**WEST SUSSEX COUNTY COUNCIL
STRATEGIC PLANNING CONSULTATION**

SUBJECT: R/181/15/PL - Erection of 2 No. 3 bed dwellings, demolition of existing garage & shed & erection of new car port. Resubmission following R/305/14/PL. This application affects the character & appearance of the Station Road Conservation Area.

Land To The South of The Tiled Barn, Station Road, East Preston, BN16 3AR

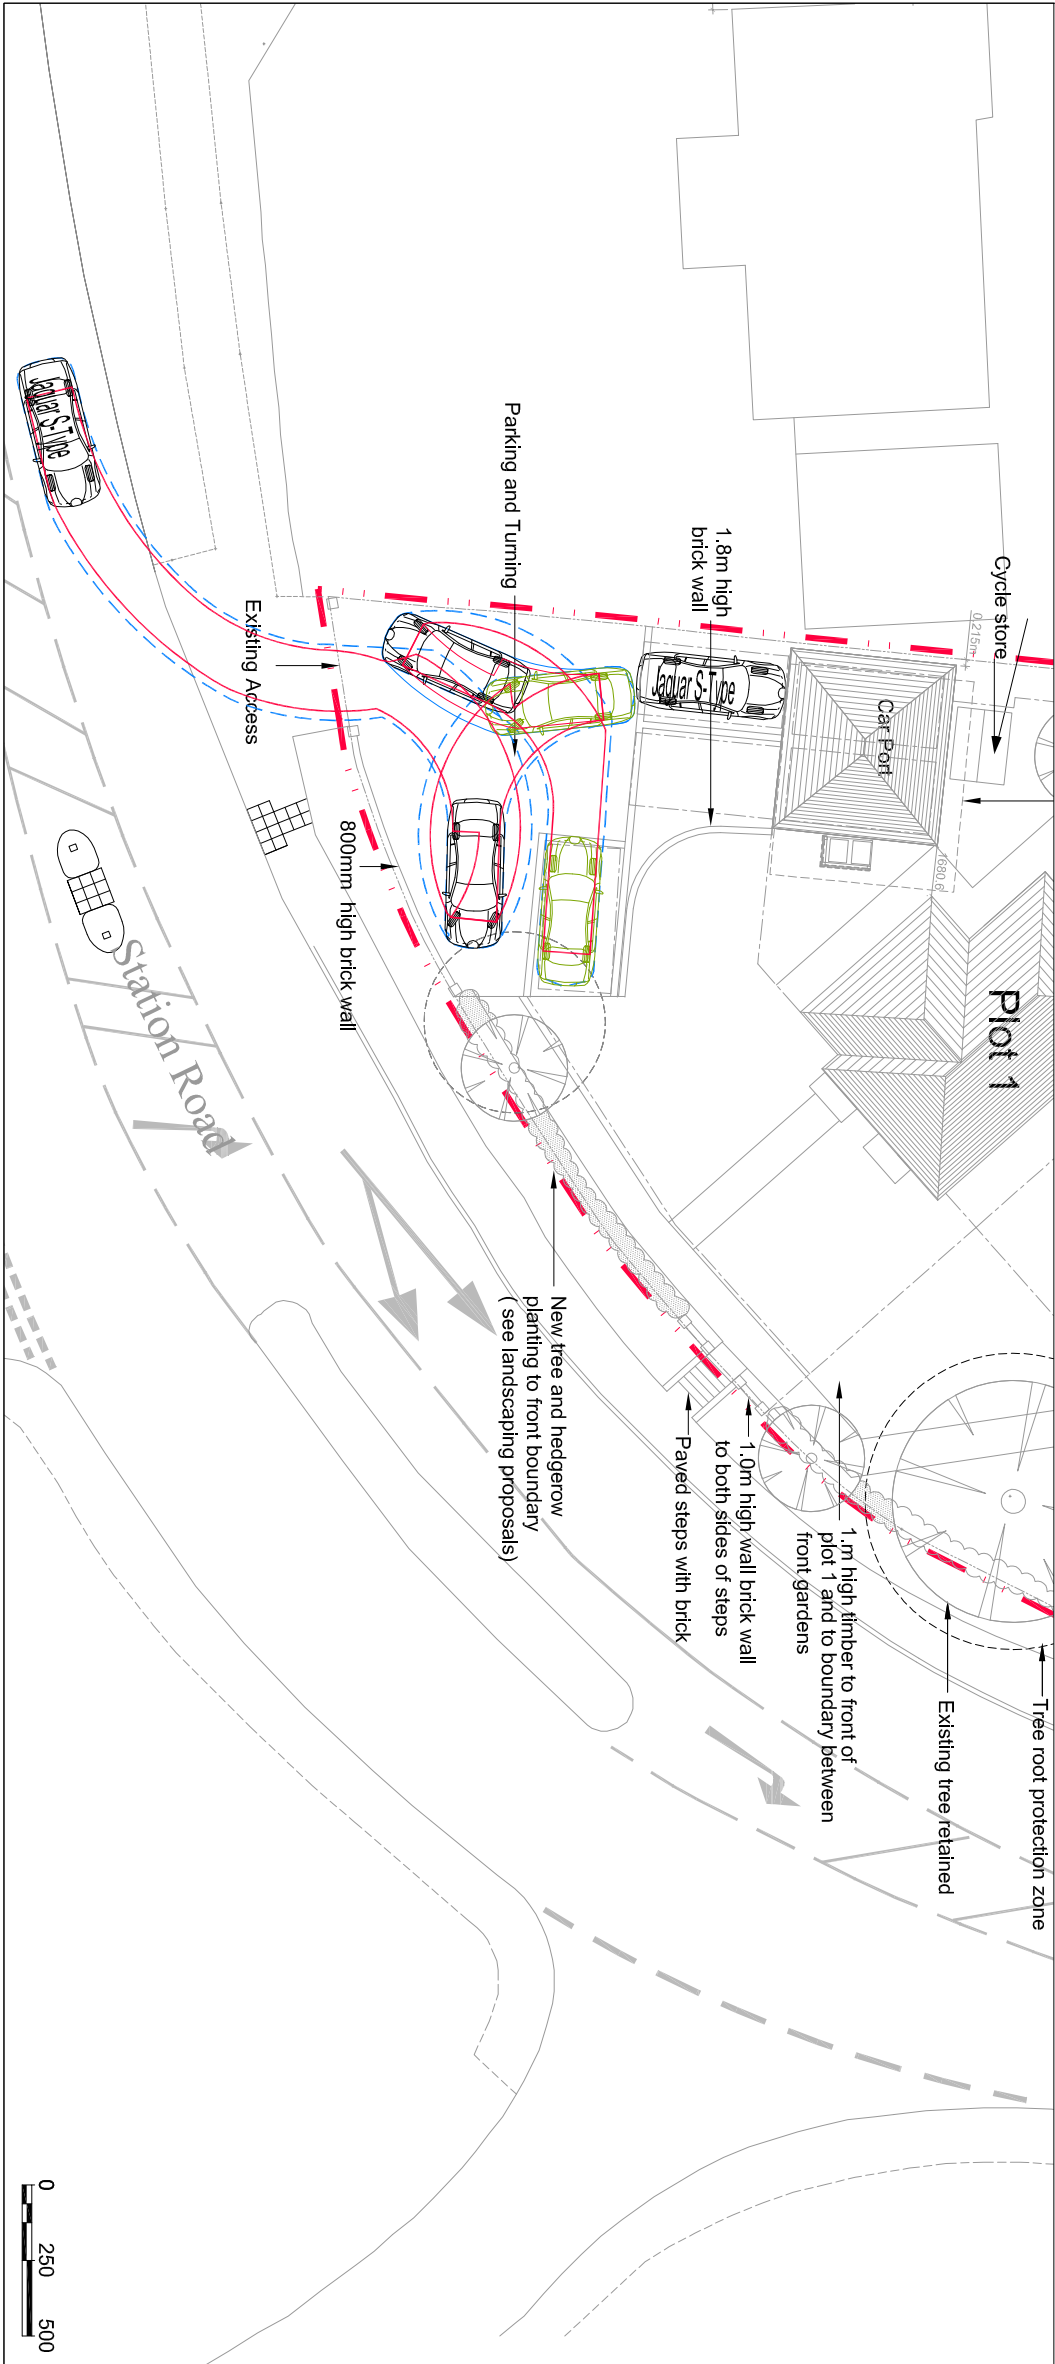
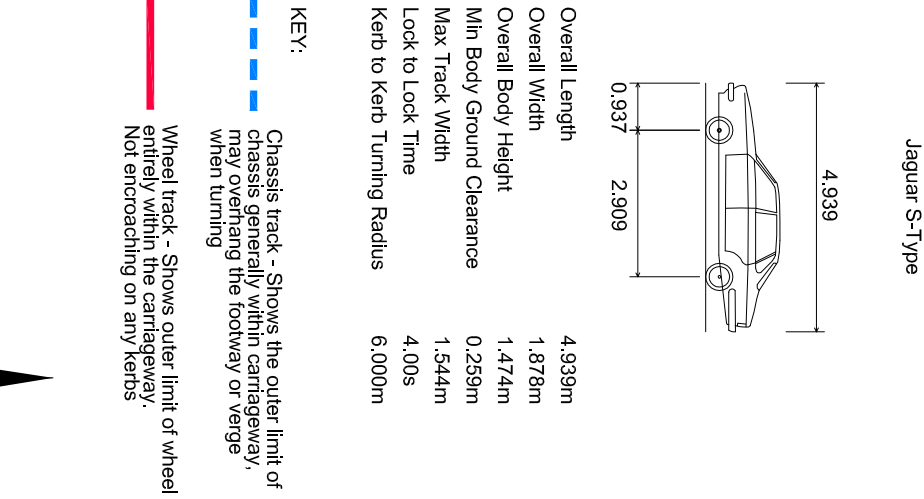
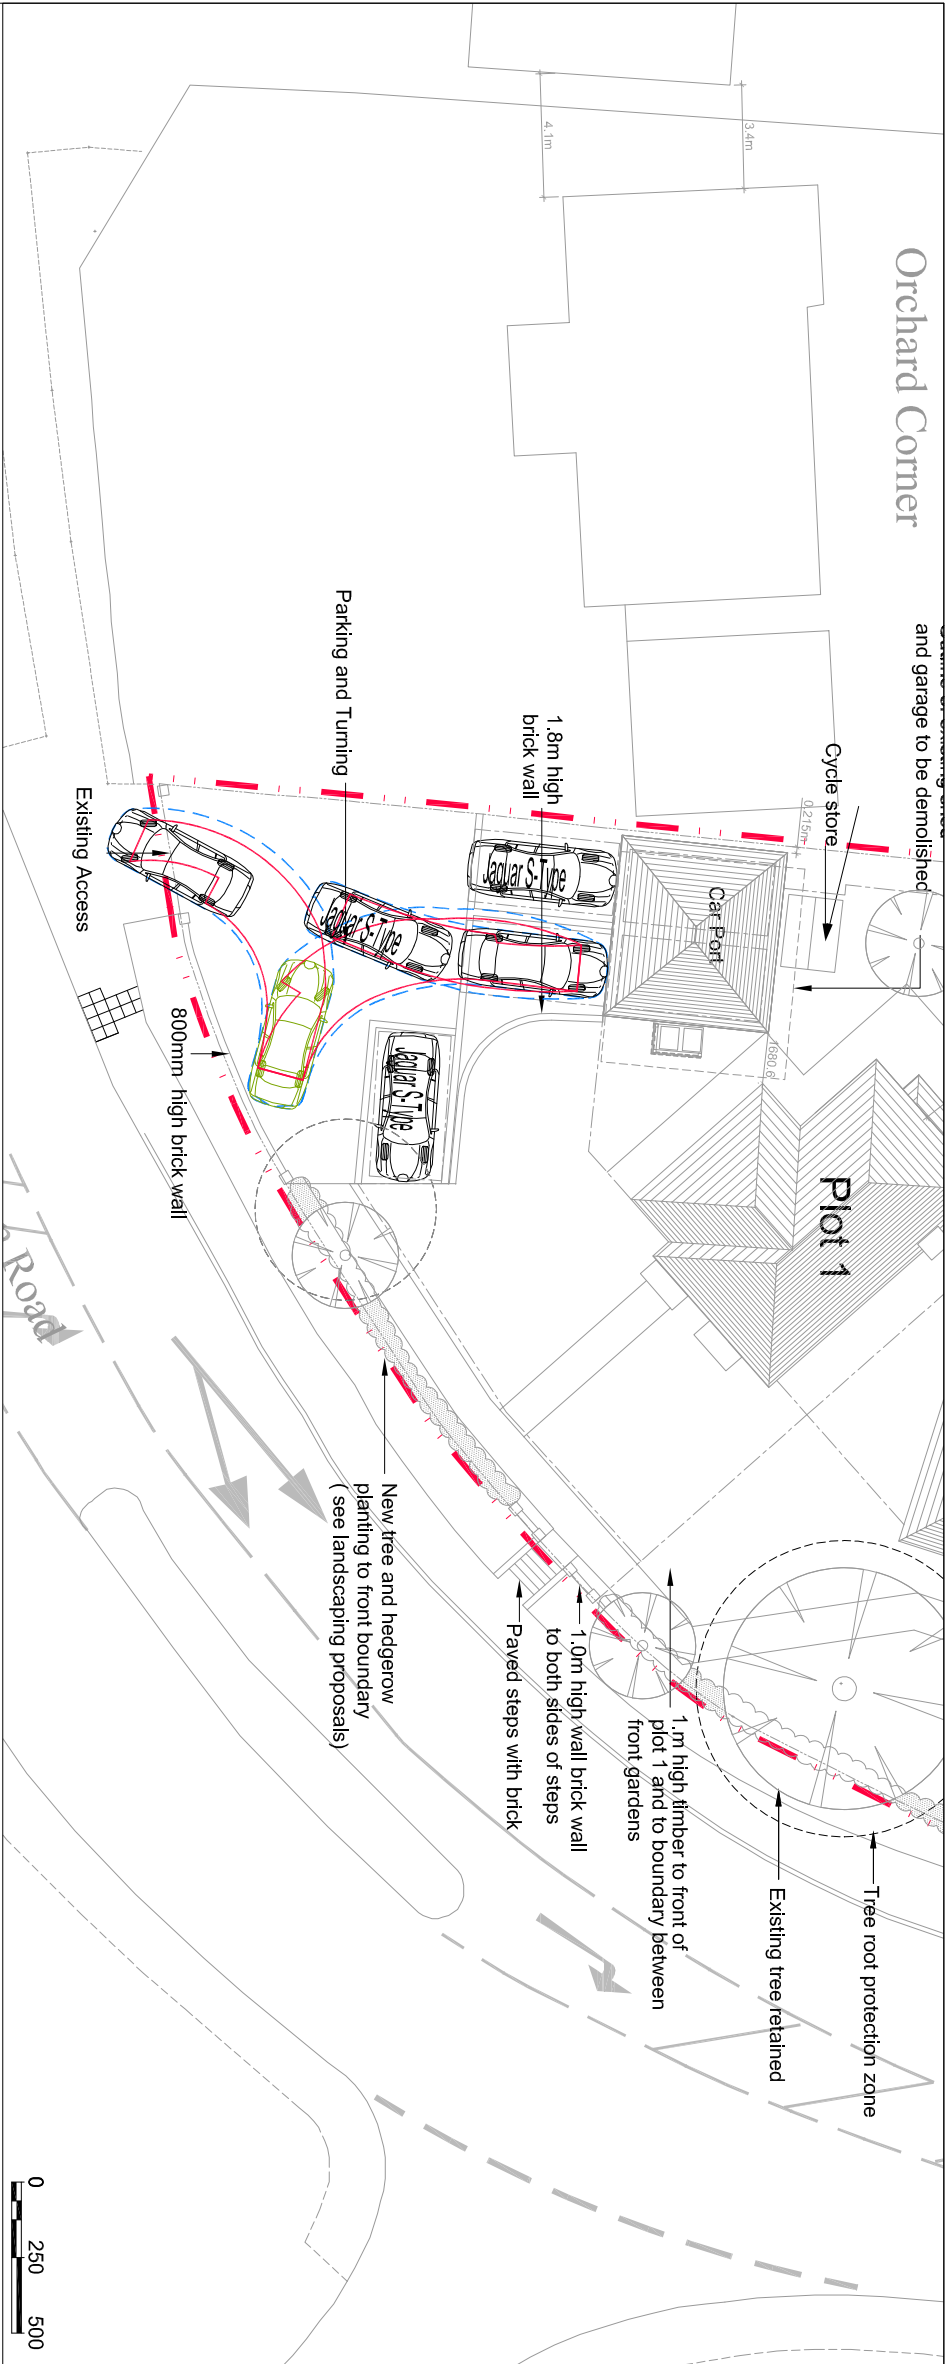
The applicant has provided plans showing the visibility splays that can be achieved from a 2.4m set back from the existing access point. The LHA are of the opinion that these are acceptable given the 30mph speed limit on Station Road and the fact this is an existing access where visibility is being improved by the applicant reducing the height of the boundary fencing/wall and removing the gates. The boundary wall either side of the access should be no more than 0.8m in height.

The plans and swept path analysis for the proposed parking arrangements and turn on site are considered acceptable, allowing vehicles to exit onto Station Road in forward gear. It was observed that an above average car size has been used in the supplied plans.
